PERKINS+WILL**MMC East Tower Expansion – City Design Comments**

To:	Al Green
From:	Jeffrey Keilman
Date:	March 19, 2018
Subject:	MMC East Tower Expansion – City Design Comments – Workshop 2 Response
Attachments	MMC IDP Design Review_prelim2

The purpose of this memorandum is to document and provide design team responses to the IOZ Design Review as provided by City of Portland Planning and Urban Development Department and follow up meetings and conversations with City of Portland Planning Staff. Comments were developed, collected, and summarized by Caitlin Cameron, Urban Designer and distributed on 03.06.2018. Subsequent meetings with City Staff occurred on 03.07.2018 and 03.15.2018.

NORTH ELEVATION

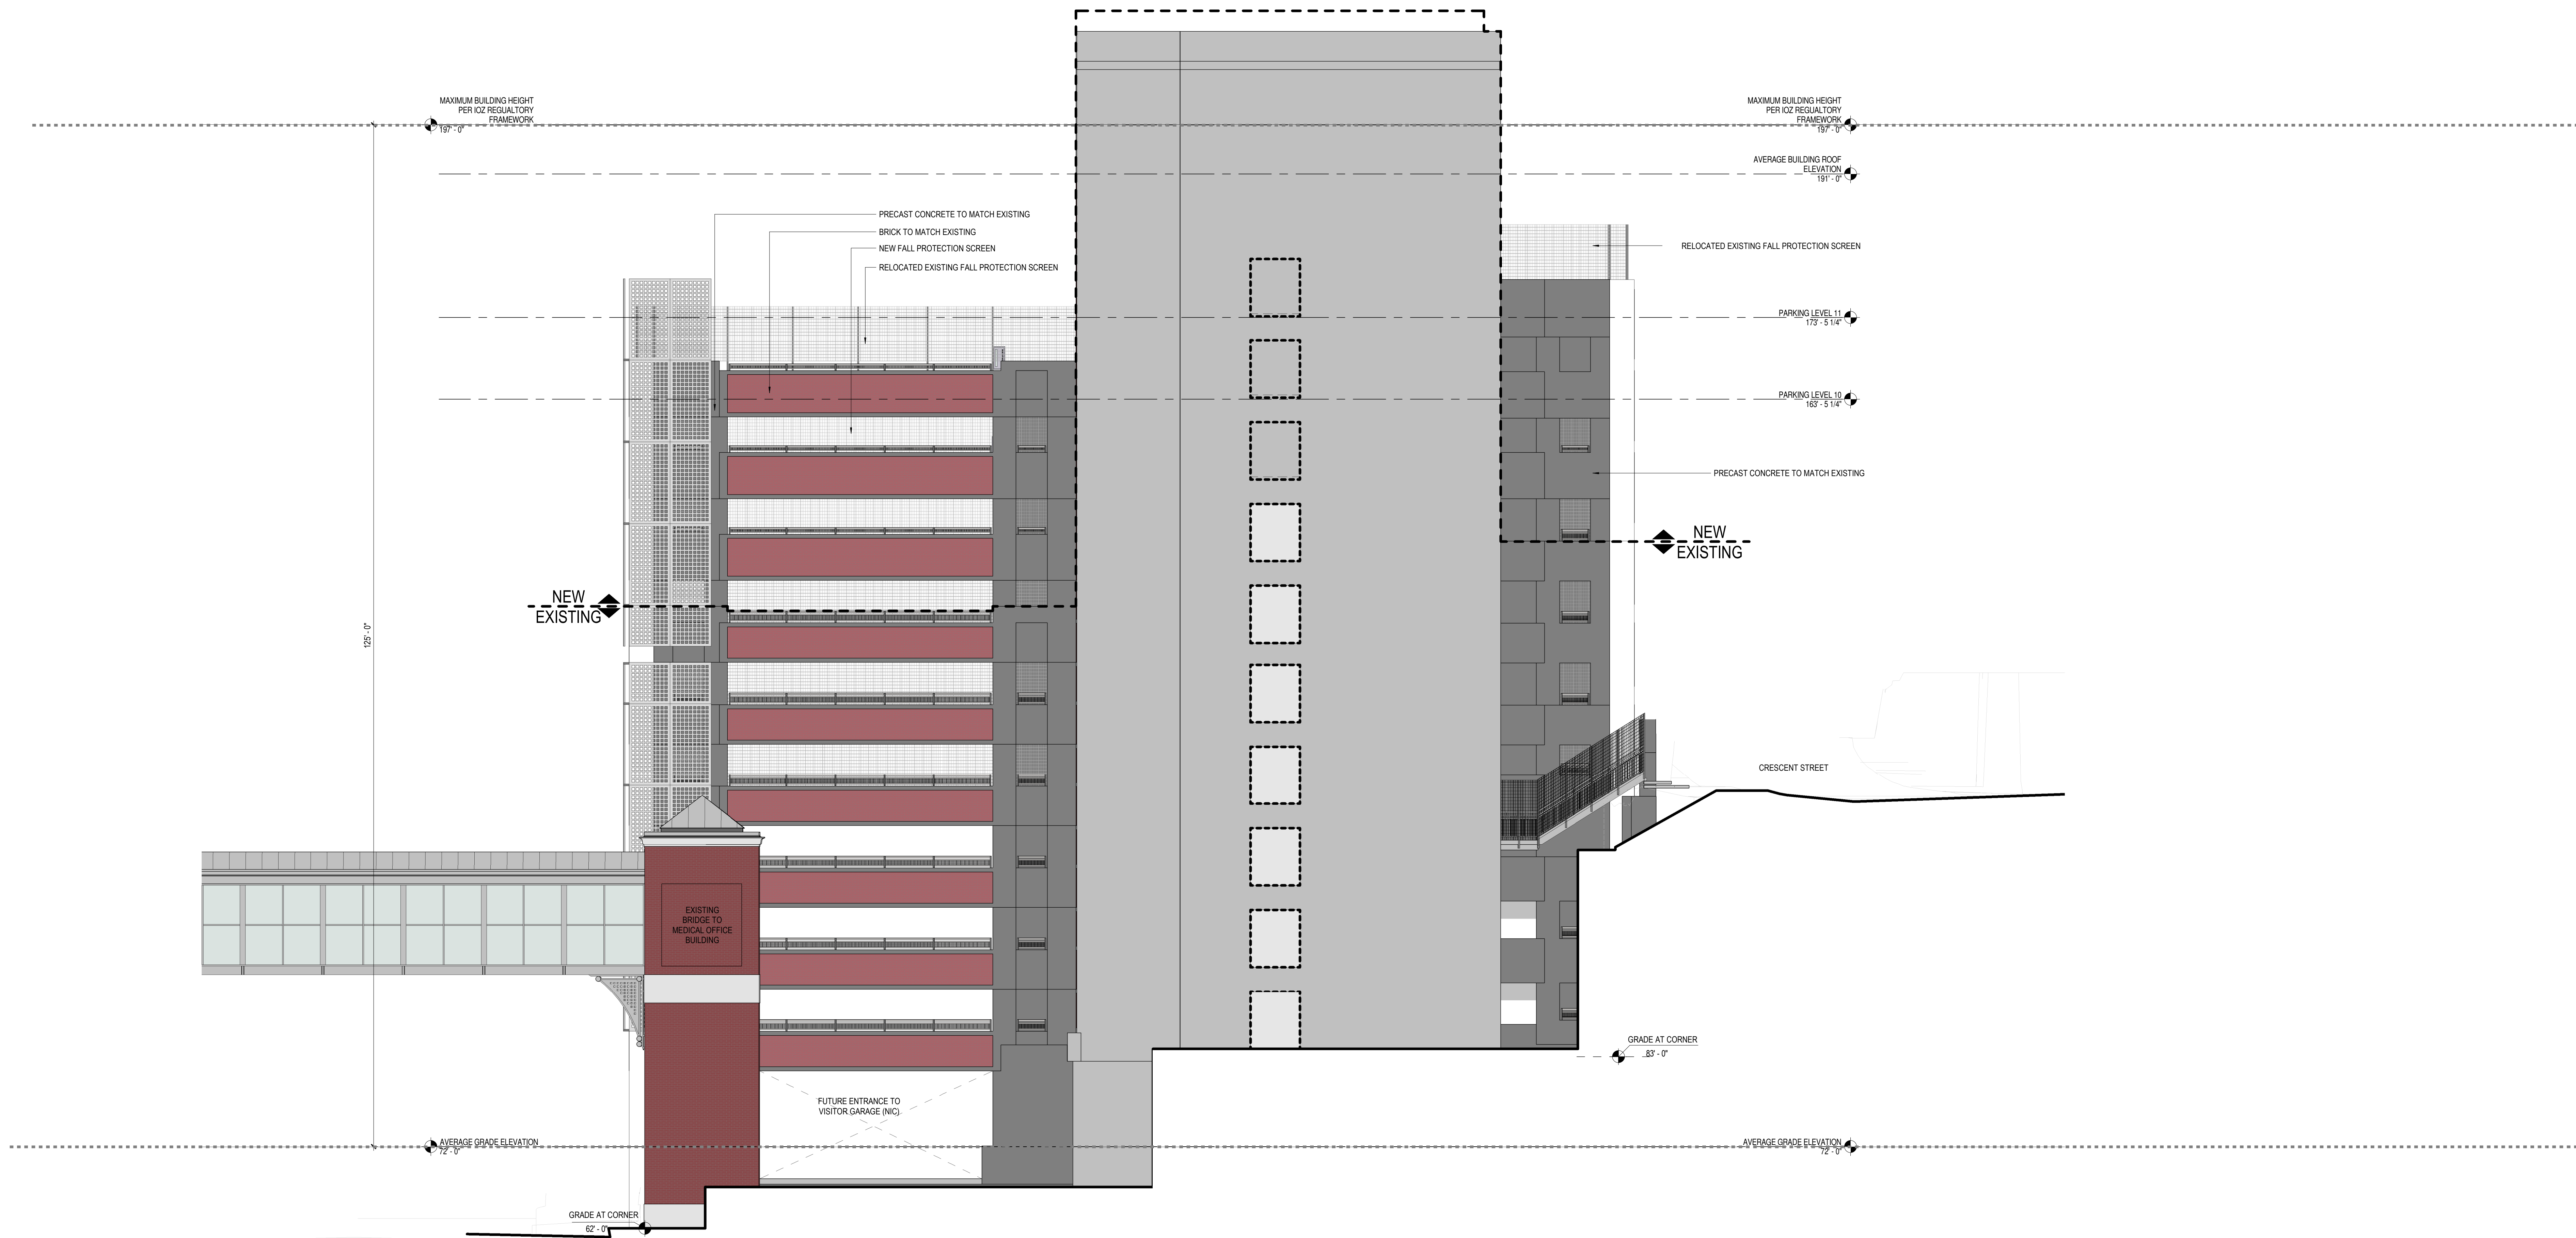
Visitor Garage: The proposal maintains the existing material palette of brick, concrete, and metal screen. *Planning Board is concerned about the prominence of the garage on Congress Street and the lack of visual interest and contribution to the public realm by using the existing material palette.*

Visitor Garage: *Congress Street is a major street and this building will become even more visible from long views as it grows in height. The garage proposal lacks visual interest from long views – articulation and visual interest are important for the garage in the forefront of the campus. Planning Board asks that the applicant re-evaluate the approach. Although staff and Planning Board acknowledge it is not realistic to completely redo the siding of the garage, consider options like adding decoration to give three-dimensional life to the façade, laser cut metal panel. The roofline is an element where visual interest could be added - Planning Board commented that the simple roof form does not have enough visual interest for the long views.*

Long views were developed for further review per recommendation of City Staff. The expansion of the Visitor Garage does increase its height but the ability to see the expansion is limited from long views. However, per comments as heard from the Planning Board and reiterated by City Staff, options were developed on how to modify the existing screening elements on the garage. Upon review, an option that extends the screening above the last spandrel panel was desirable by all that reviewed for it broke the horizontal plane of the roofline and created a layering between the screens, fall protection, and precast concrete panels.

Long views were developed for further review per recommendation of City Staff. The expansion of the Visitor Garage does increase its height but the ability to see the expansion is limited from long views. However, per comments as heard from the Planning Board and reiterated by City Staff, options were developed on how to modify the existing screening elements on the garage. Upon review, an option that extends the screening above the last spandrel panel was desirable by all that reviewed for it broke the horizontal plane of the roofline and created a layering between the screens, fall protection, and precast concrete panels.

WEST ELEVATION

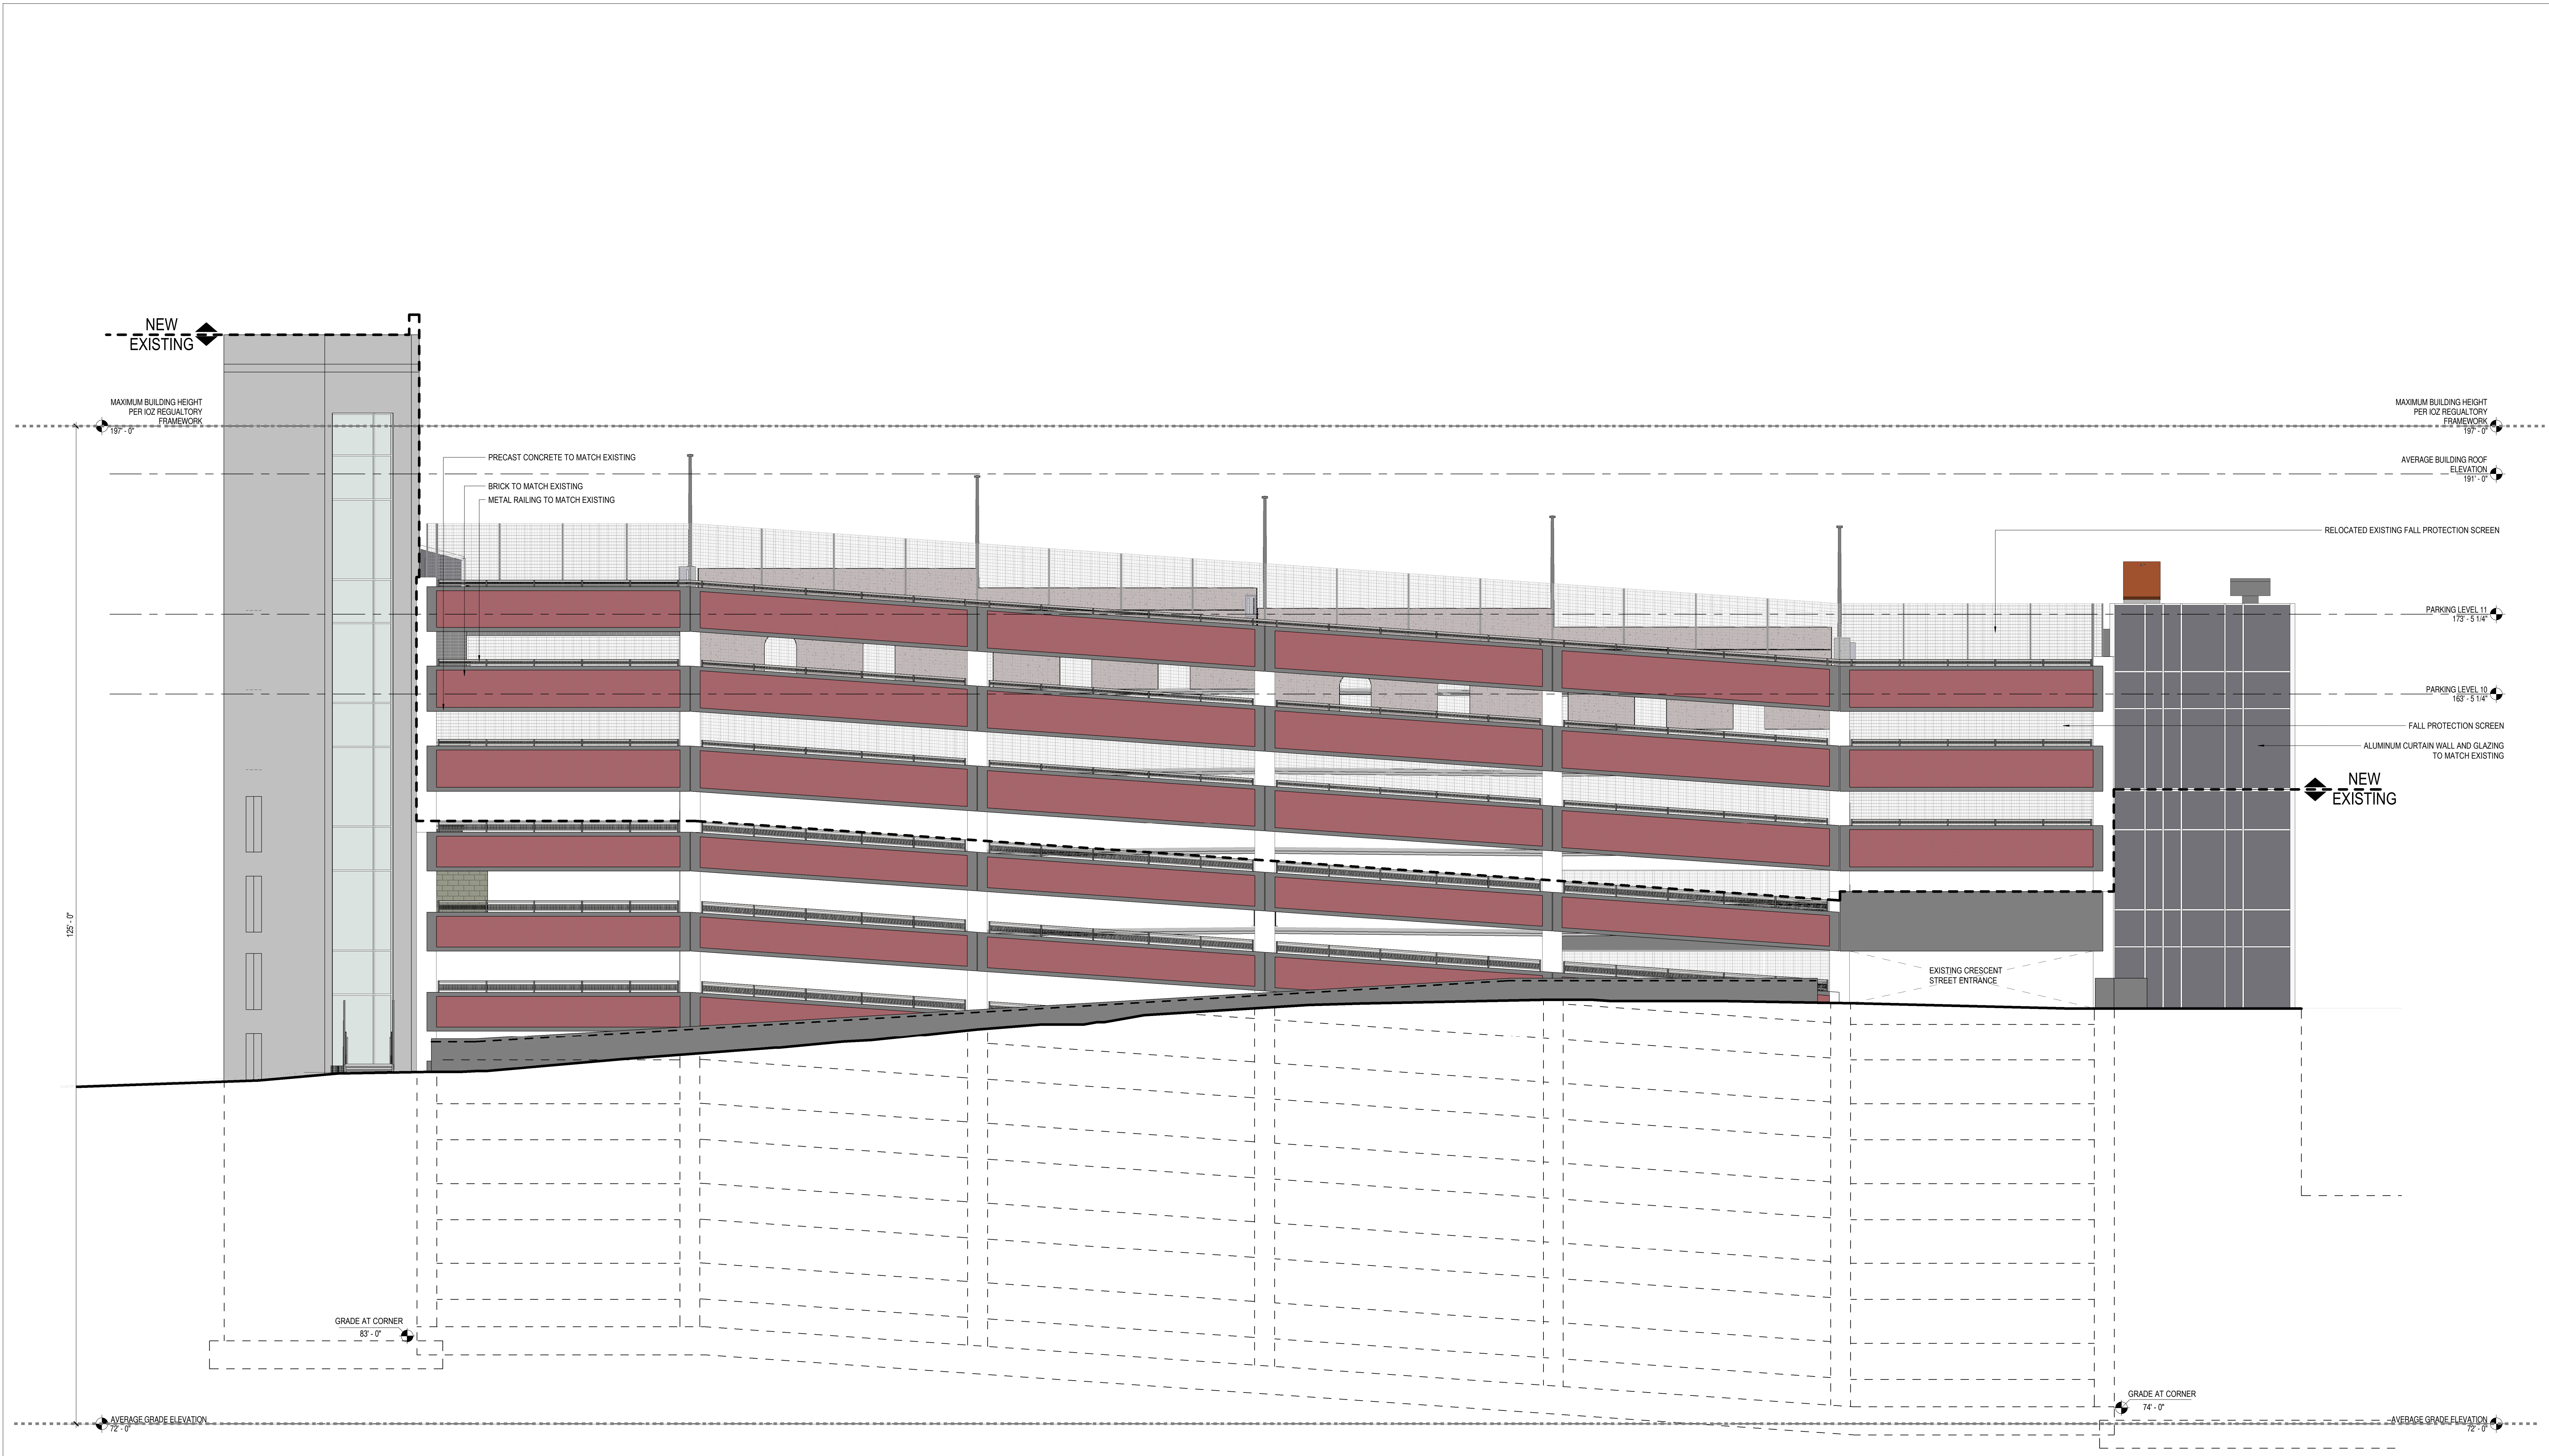
Planning Board commented on the lack of visual interest on upper floors and feel this guideline is not met – roofline, façade material, fall protection/screen design are possible architectural elements that can address this guideline. Street activation guideline is met, see comments 7. above.

Long views were developed for further review per recommendation of City Staff. The expansion of the Visitor Garage does increase its height but the ability to see the expansion is limited from long views. However, per comments as heard from the Planning Board and reiterated by City Staff, options were developed on how to modify the existing screening elements on the garage. Upon review, an option that extends the screening above the last spandrel panel was desirable by all that reviewed for it broke the horizontal plane of the roofline and created a layering between the screens, fall protection, and precast concrete panels.
